**Re: Erection of Rear 2 Storey Extension to Farmhouse and raise height
of detached garage roof to provide storage area.**

At: Unit 1, "Blacker Grange Farm", off Barnsley Road, Blacker Hill, Barnsley.

Application No: 2011 / 0644. Application Date: 26th. May 2011.

PROJECT	Unit 1
CLIENT	Mr. & Mrs. M. Wilkinson
TITLE	Property as Proposed
ADDRESS	"Blacker Grange Farm", Blacker Hill, Barnsley.
DRAWN BY	999
SCALE	1:100; 1:50
DATE	May.11
DRAWING No	741-05

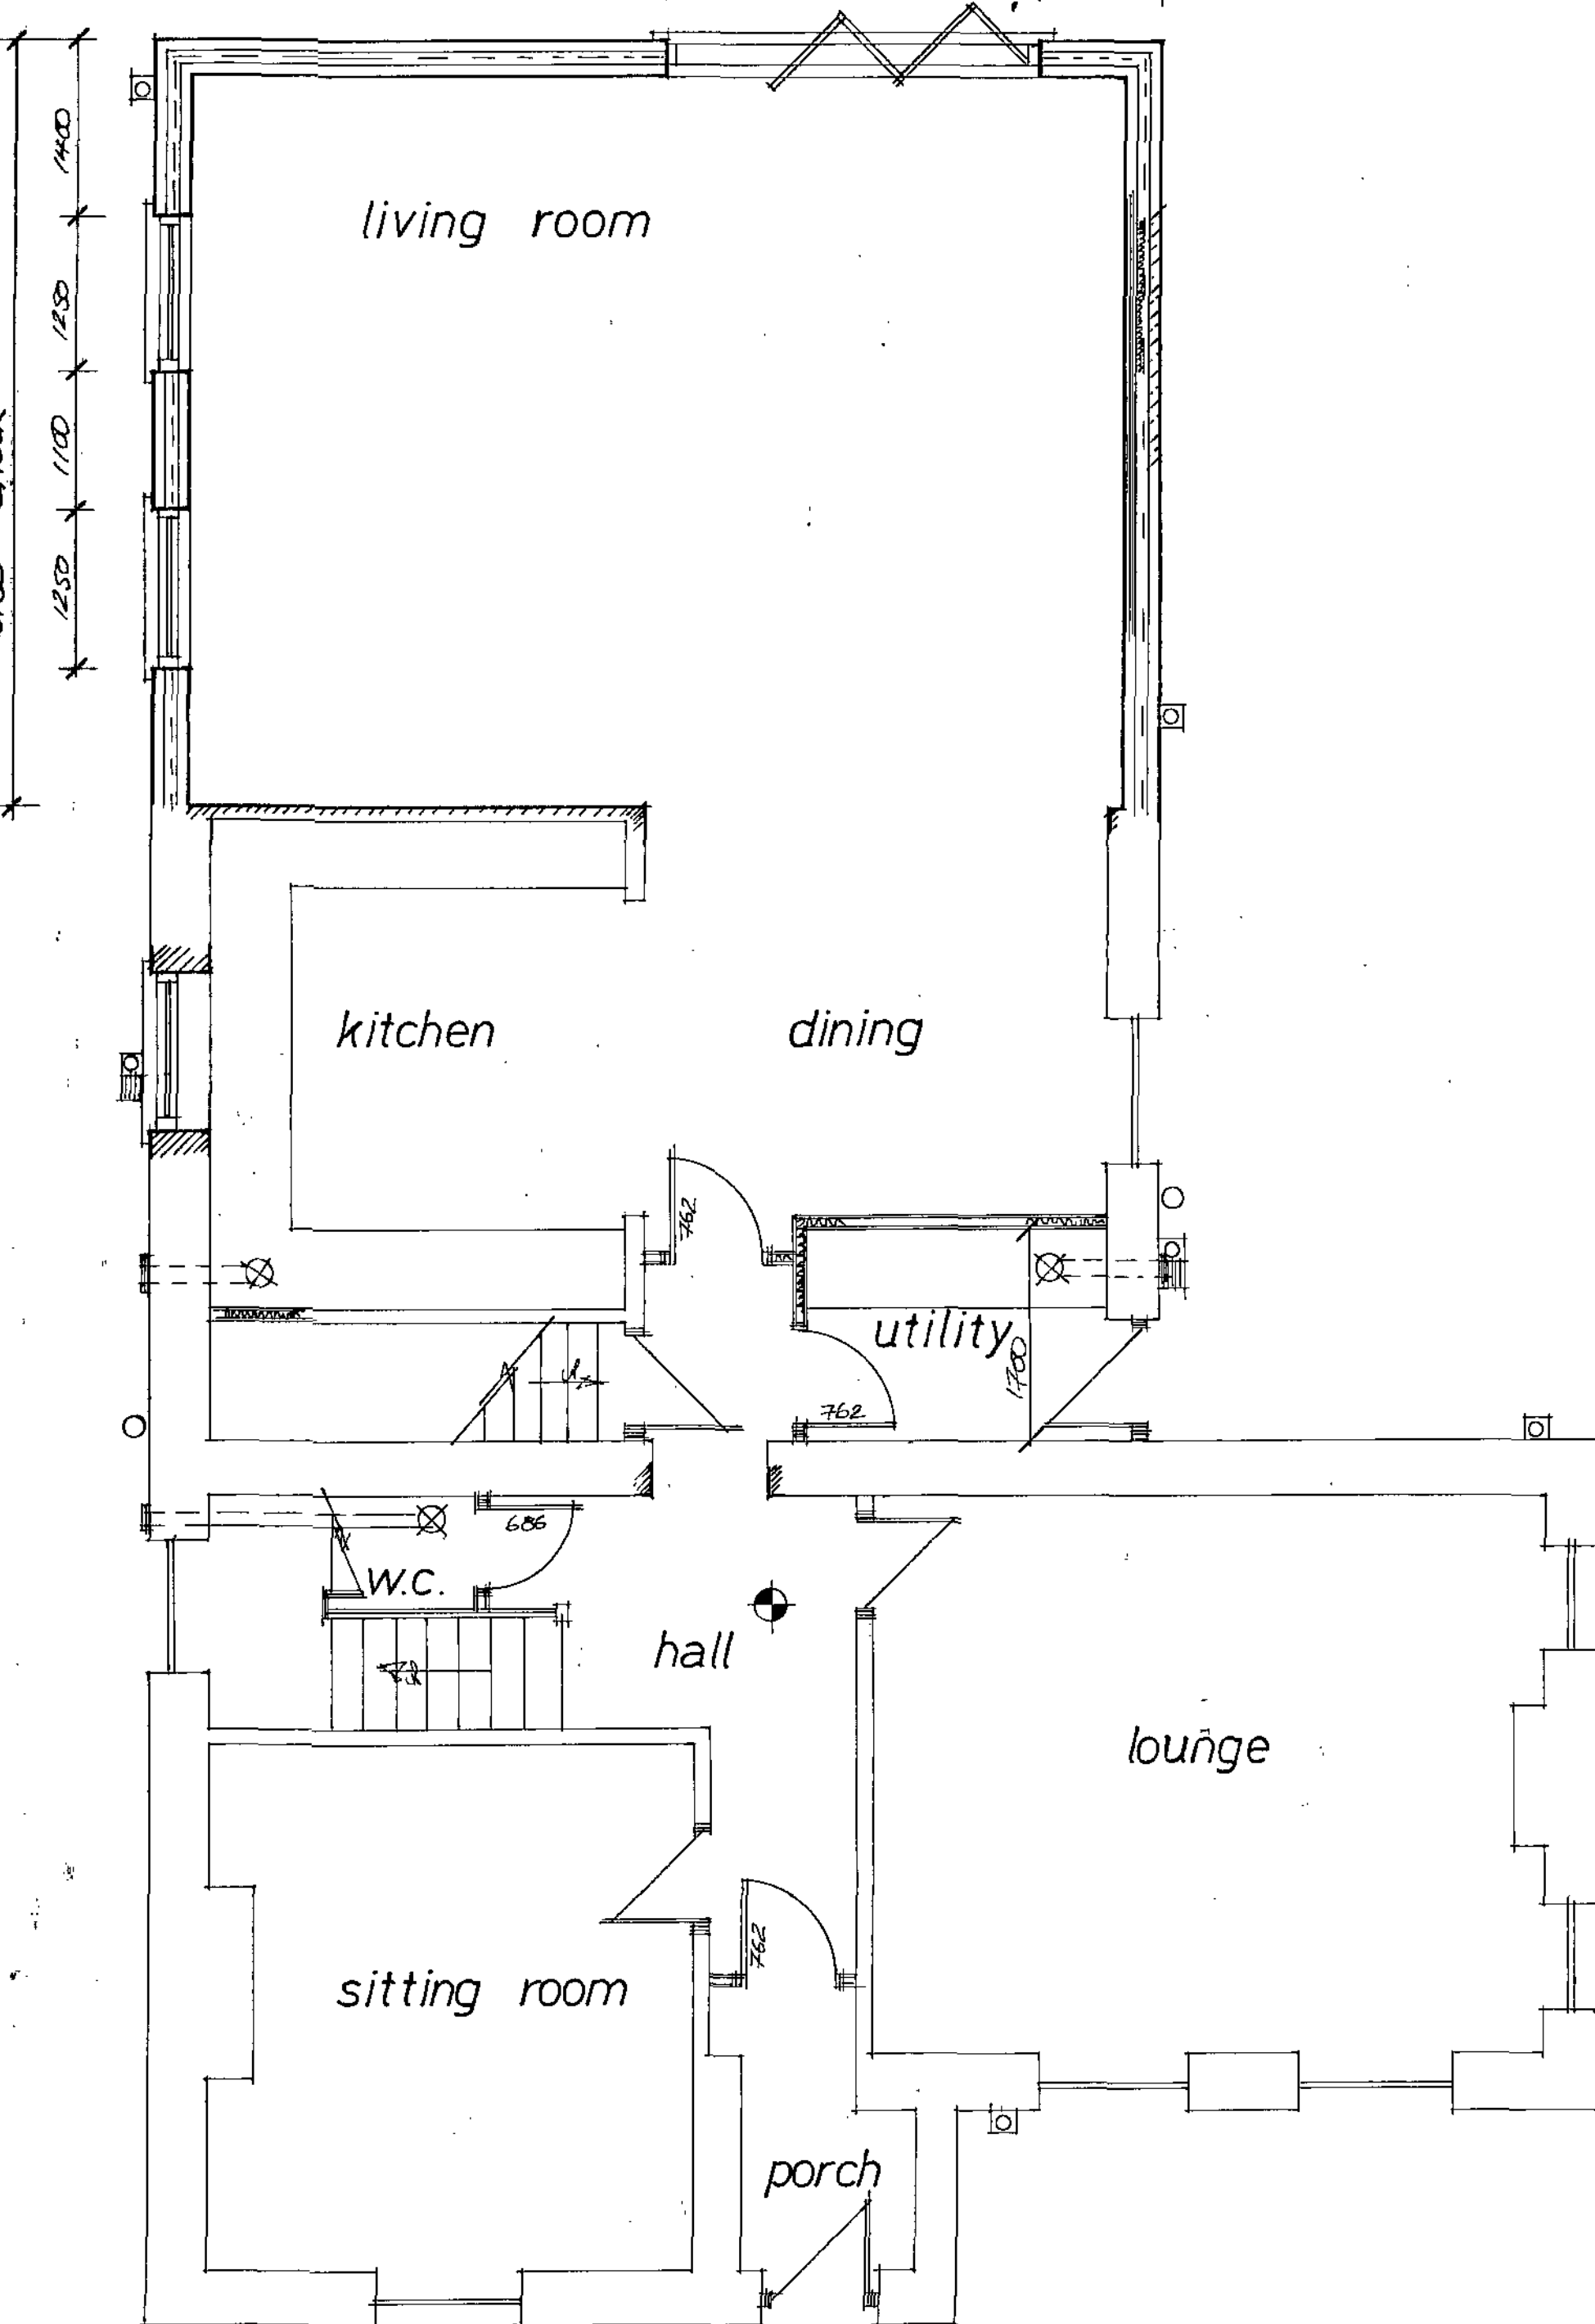
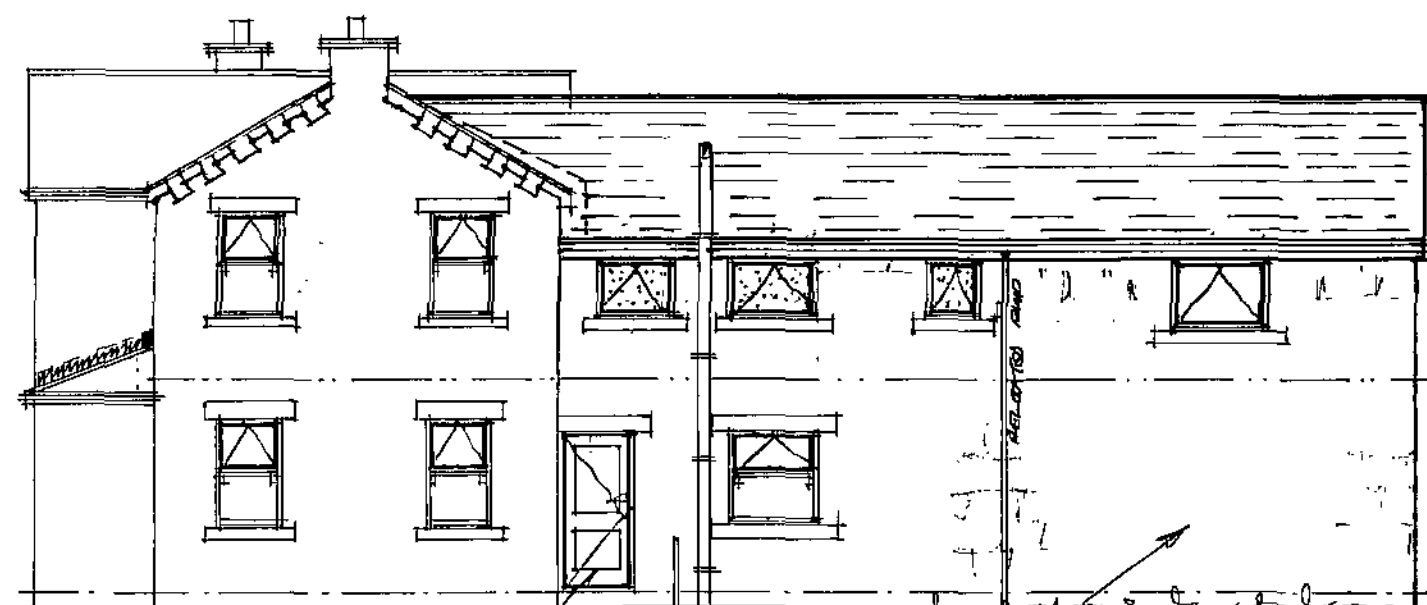
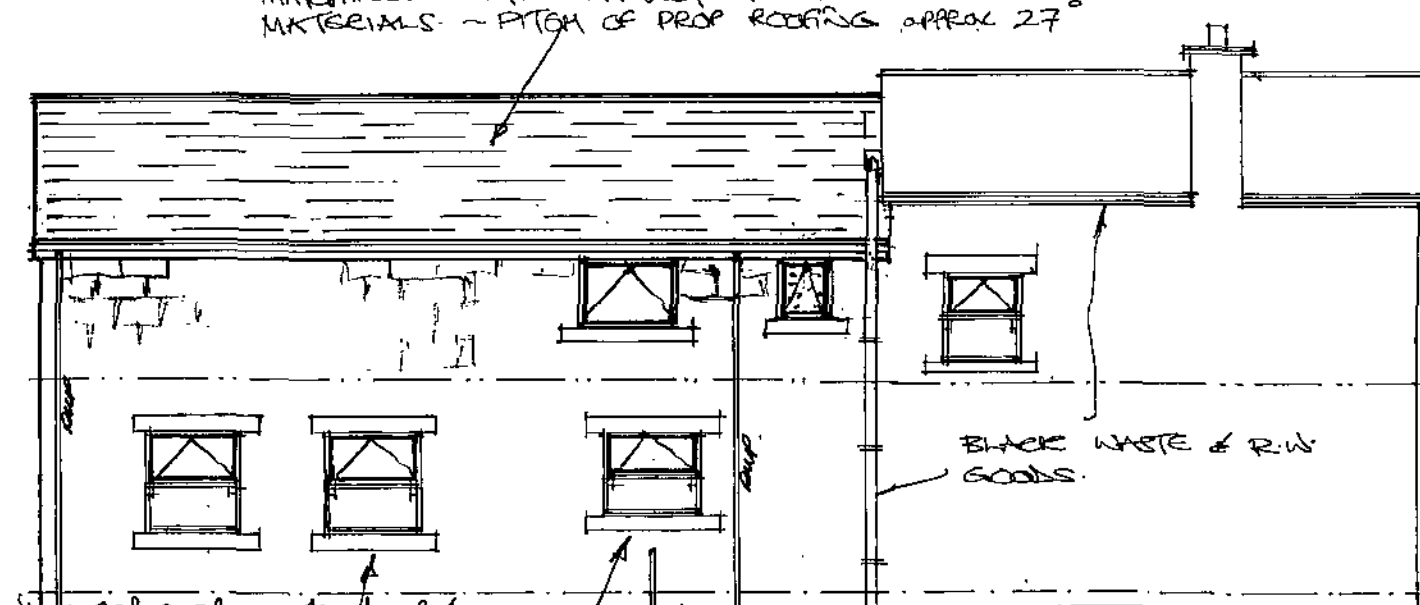
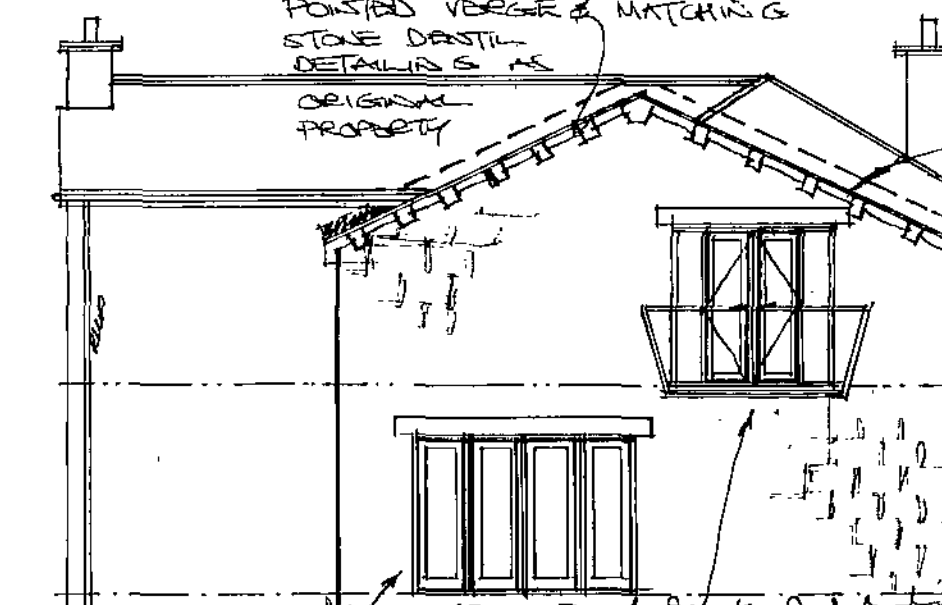
- i) the lowering of the eaves height to this extension construction;
- ii) dropping the window levels;
- iii) introduction of stone dentil detailing to the proposed verges, all as matching the original detailing on the existing property.
